Subject: **Hong/Kao Residence Remodel/Addition and new Detached Accessory Dwelling Unit
5425 W Mercer Way
Permit No. 2306-124**
Quantum Project #23127.01

We have received the correction notice on the above-referenced project dated 9/23/2023. Below are our responses to the structural comments. All changes to the drawings due to a plan check comment have been clouded on the drawings.

ADU ROOF FRAMING PLAN

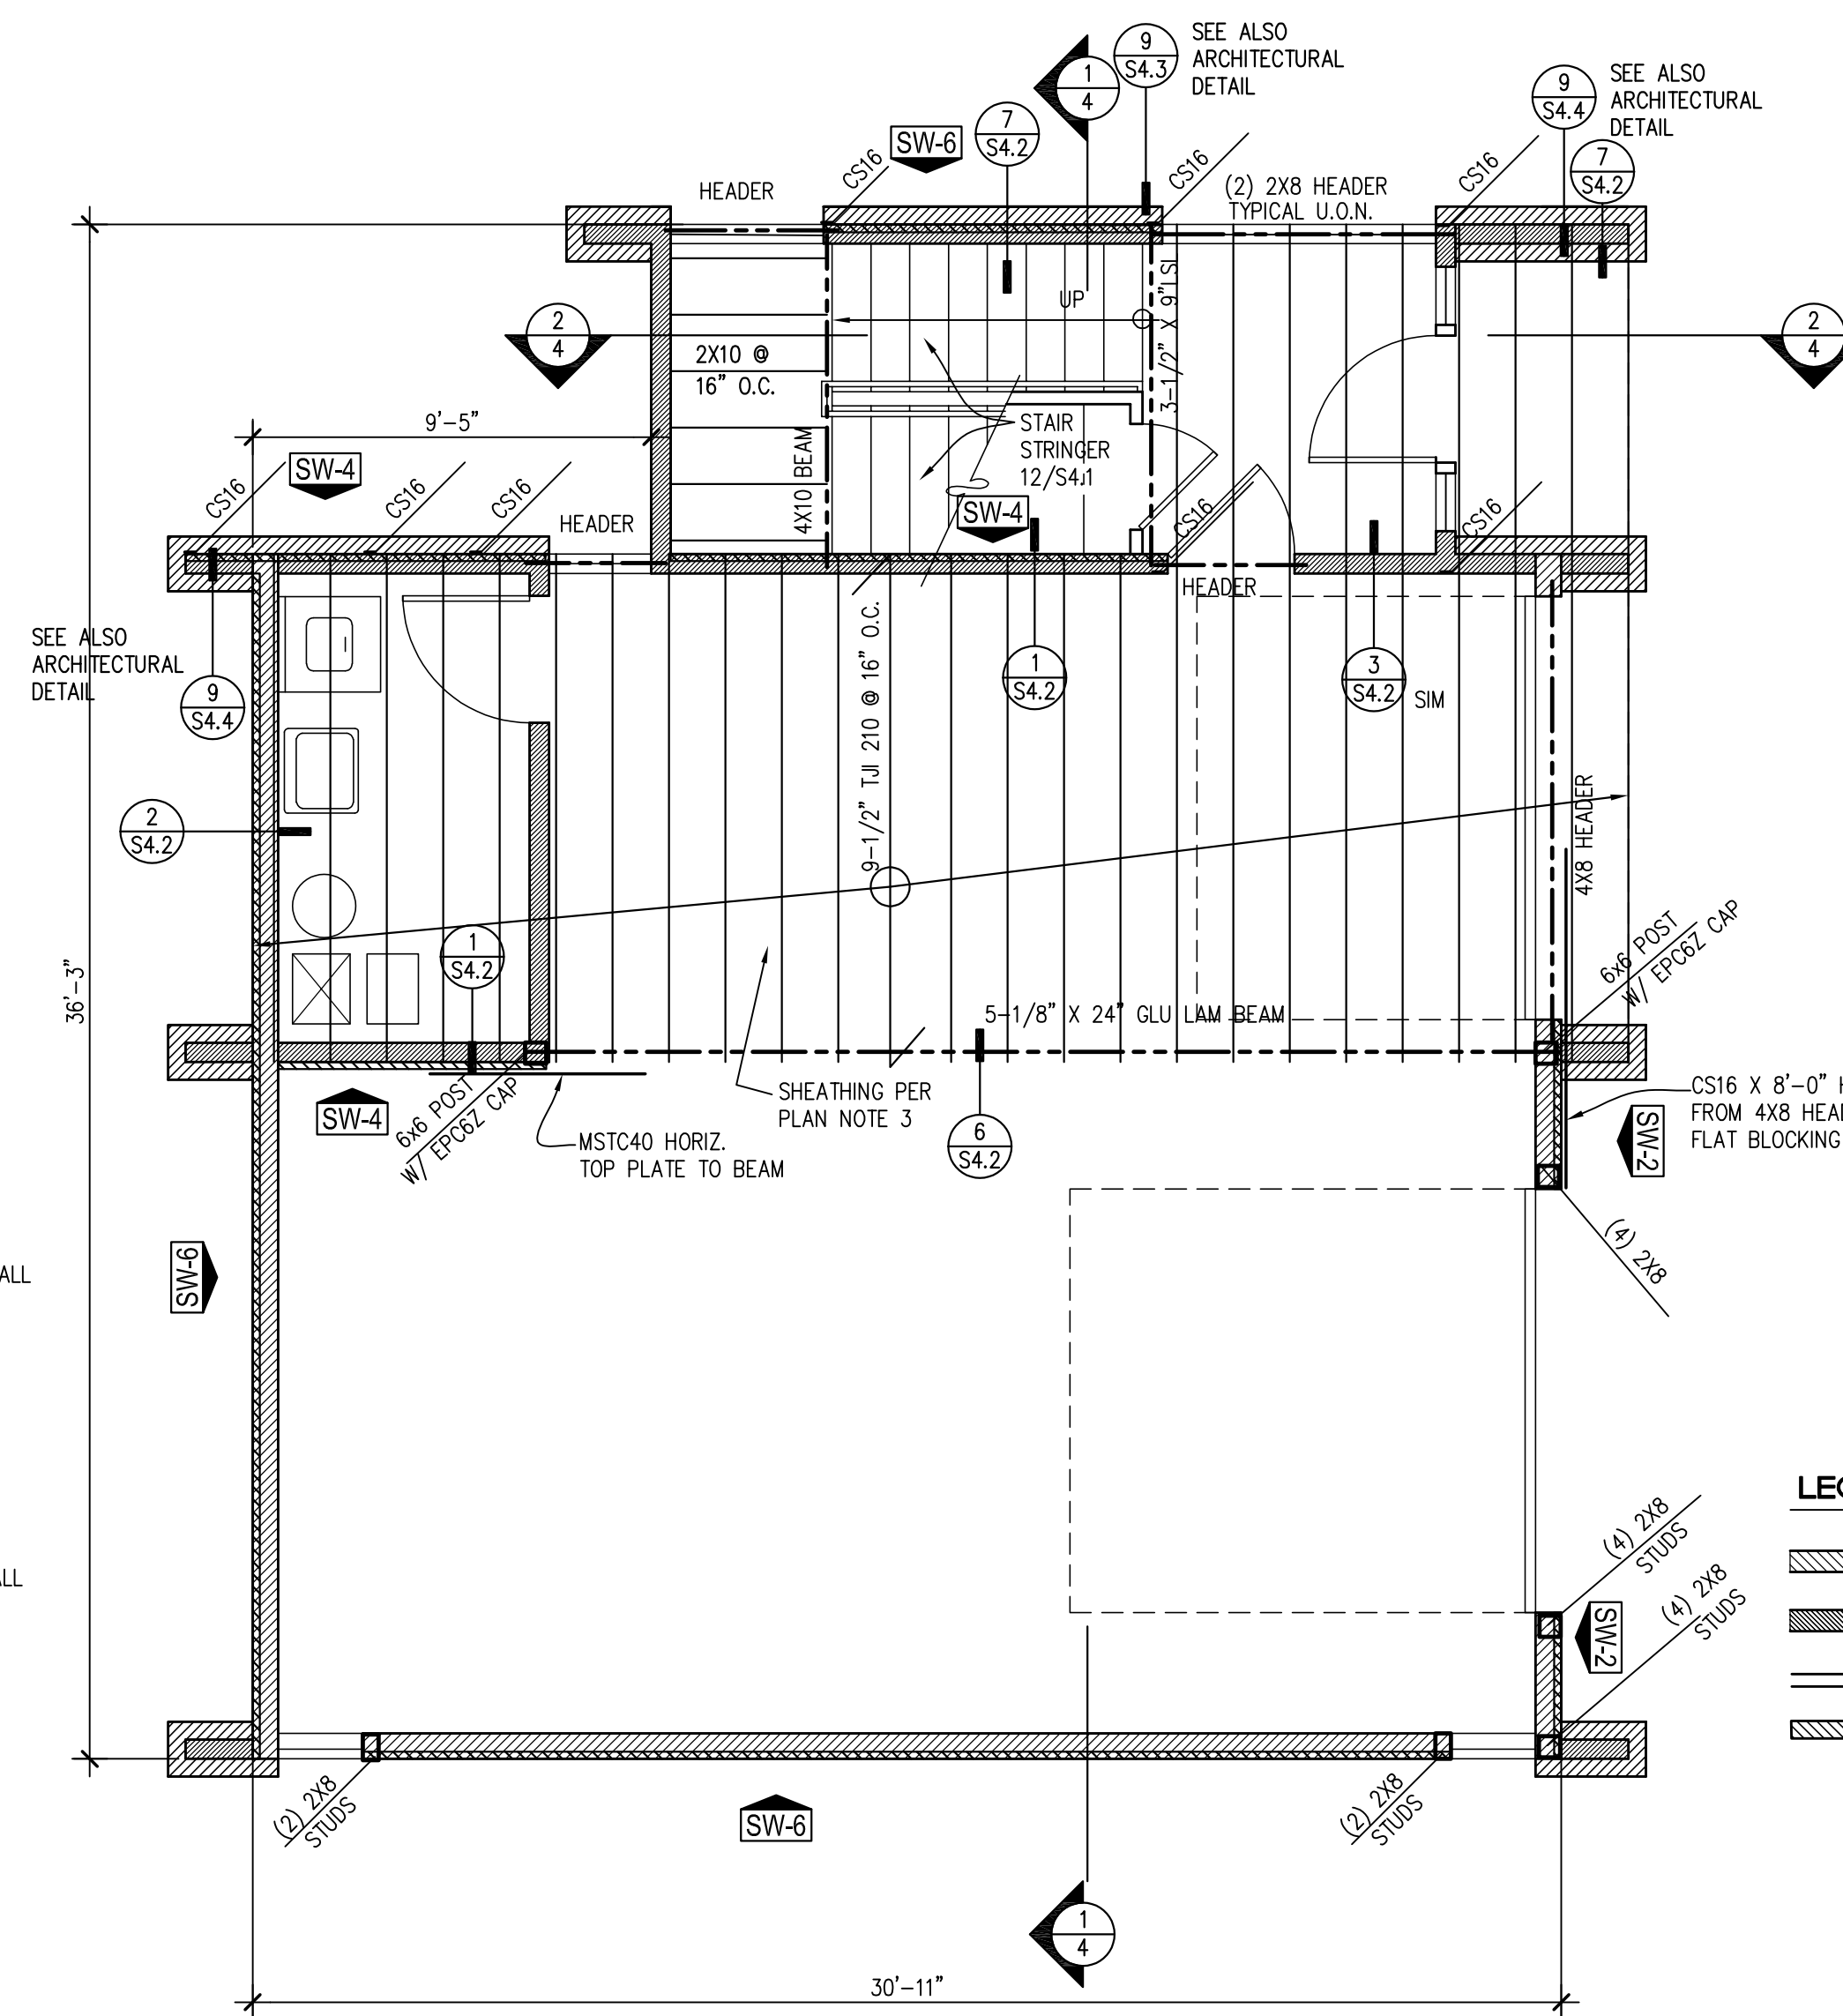
36. The ADU Roof Framing Plan on DADU Sheet 2.0 shows the E.1 & E.2 shear walls as short segments (SW-2); however, this wall at the roof level would be the full width of the double-high garage (approximately 16'). Please clarify. Also, the end studs should be full height studs; otherwise, holdowns between the upper and lower levels should be provided. Please coordinate with pages 215 – 218 of the calculations.

The wall panels are not shown as full width over the garage door because the garage door is 12'-0" tall (see Sheet S3.0) and the stud wall is 18' tall. Horizontal blocking and strapping are provided at the Upper Floor Framing Plan to transfer the loads around the door opening. Engineering judgment was used to model the building for load distribution. The resulting design shown on the permit drawings is conservative.

FOUNDATION PLAN

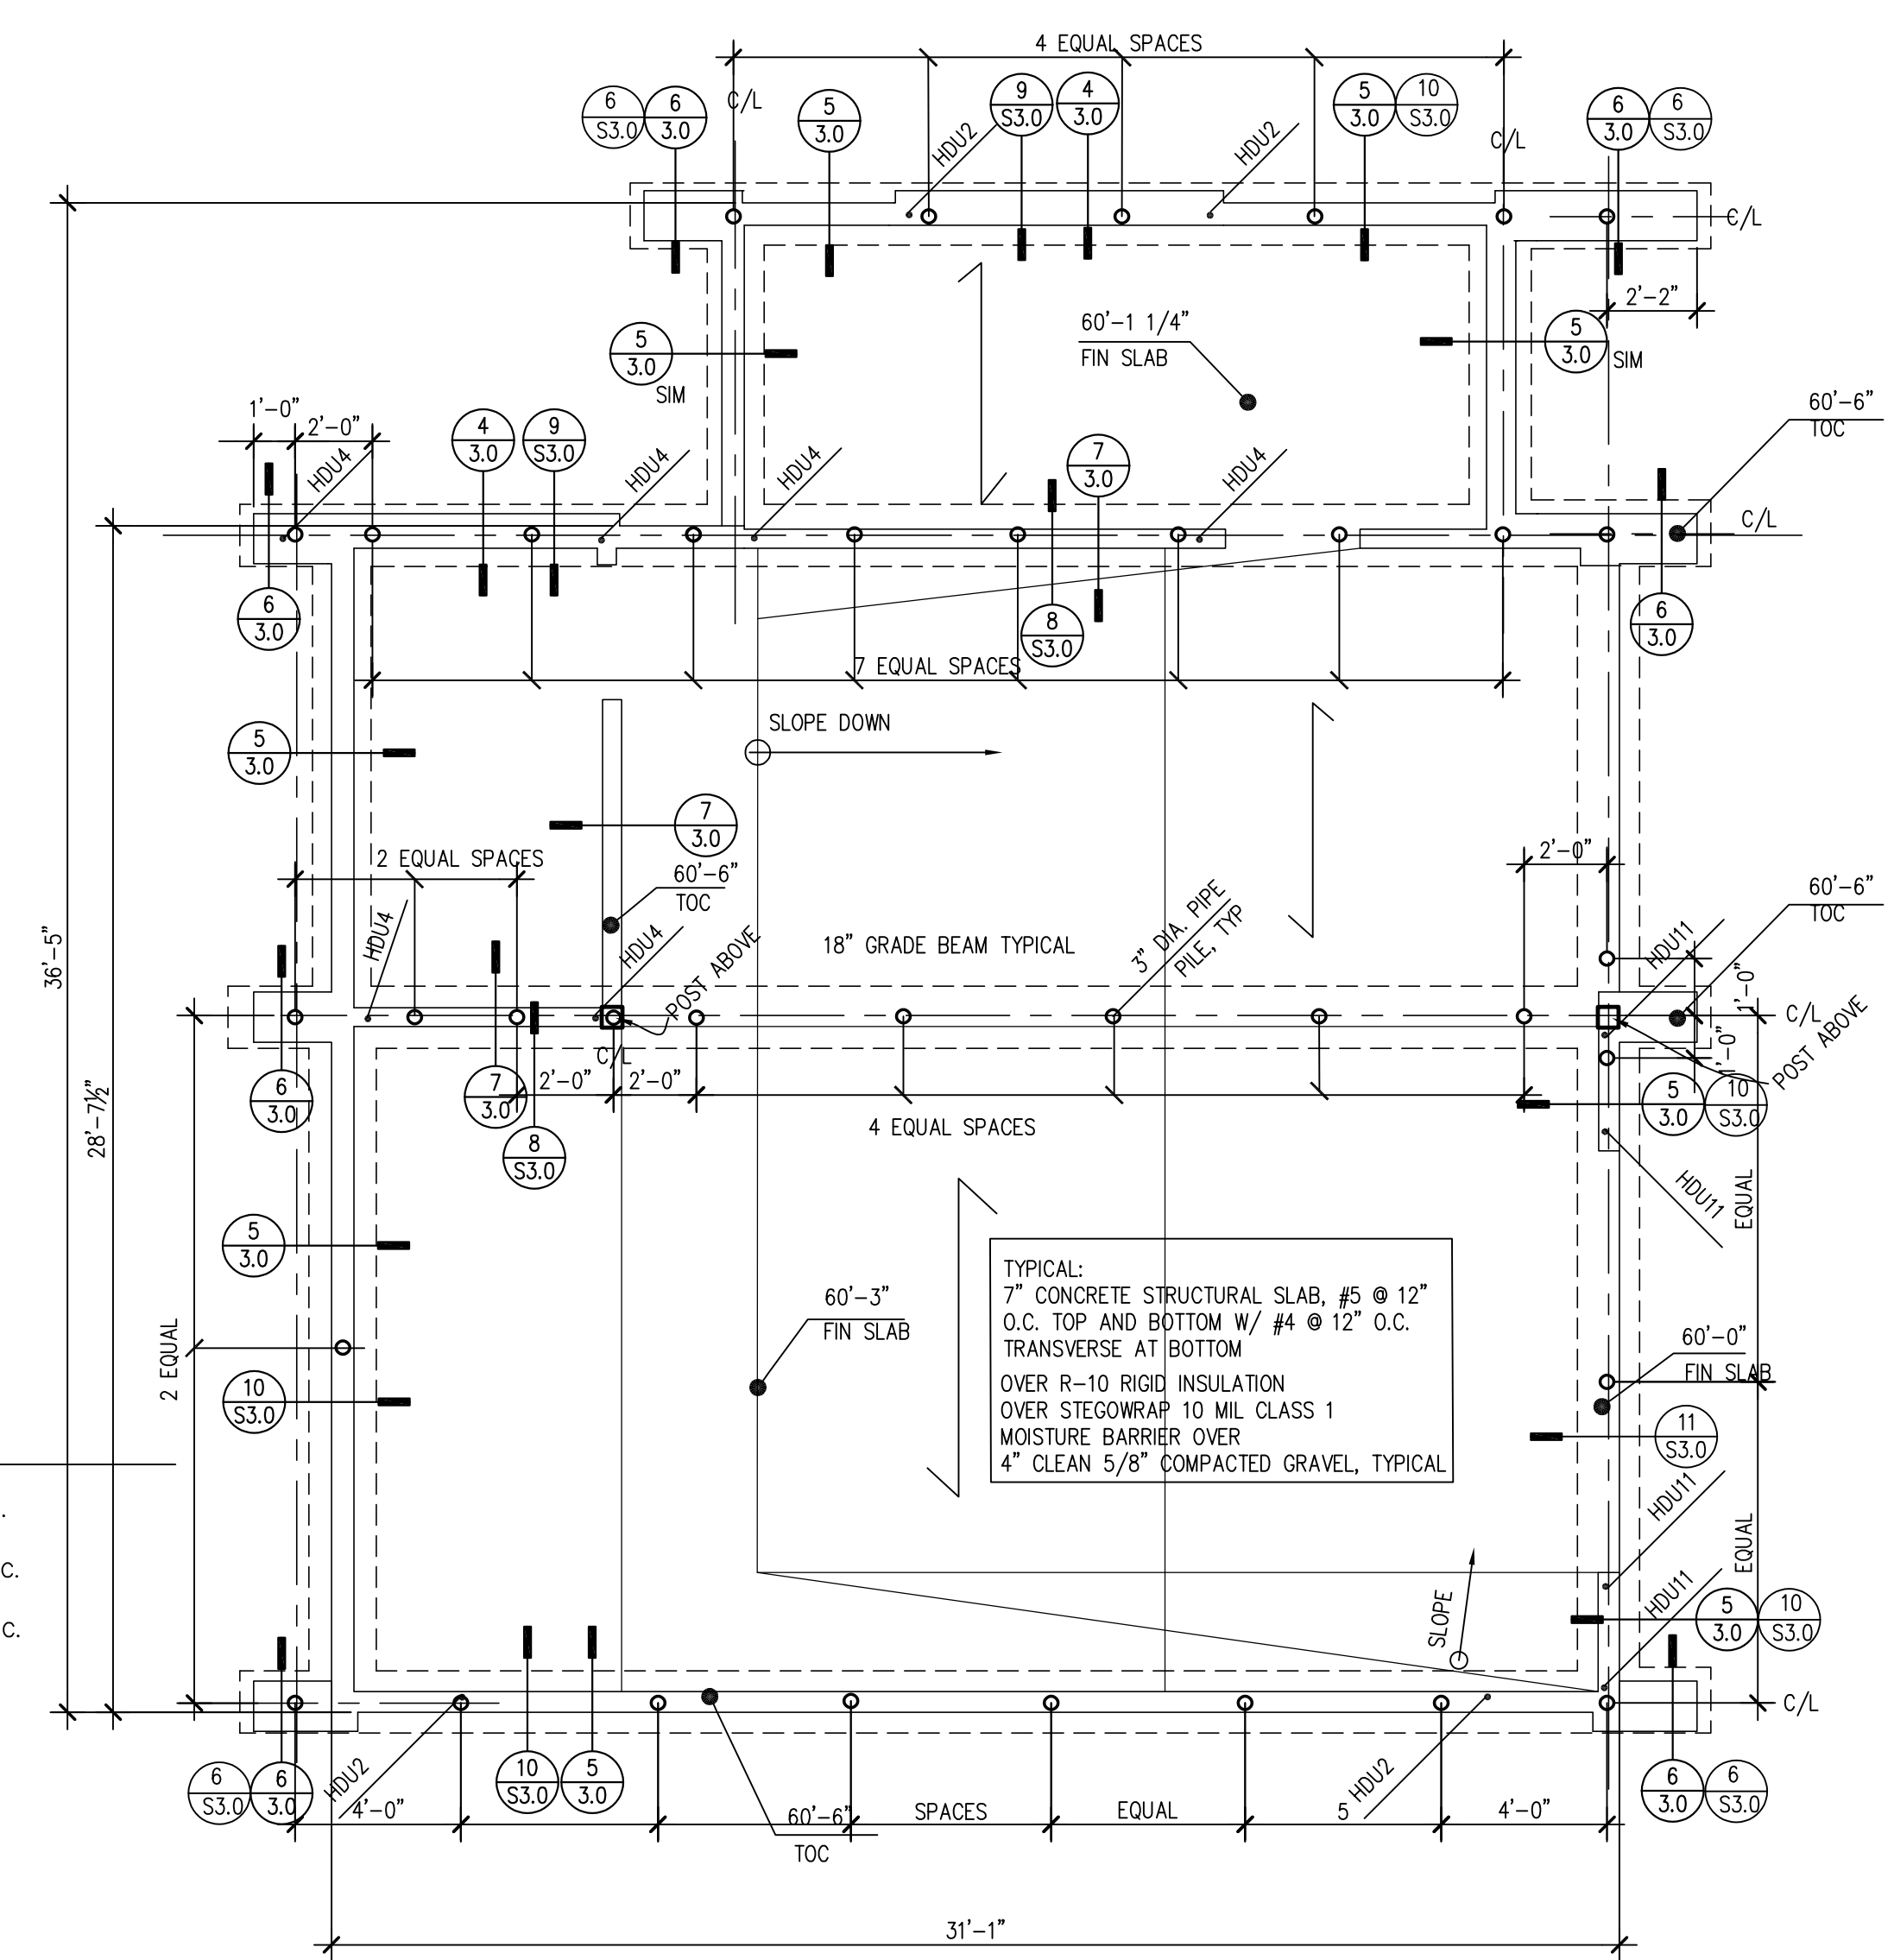
40. Page 220 of the calculations appears to require HDU2 Holdowns at each end of the lower-level W.1 shear wall. We do not find these holdowns specified on the Foundation Plan, DADU Sheet 2.0.

The conservative uplift value shown on page 220 will be resisted by the perpendicular walls at each end of the 28.5' long shear wall. Note that the perpendicular walls do have holdowns at their ends.
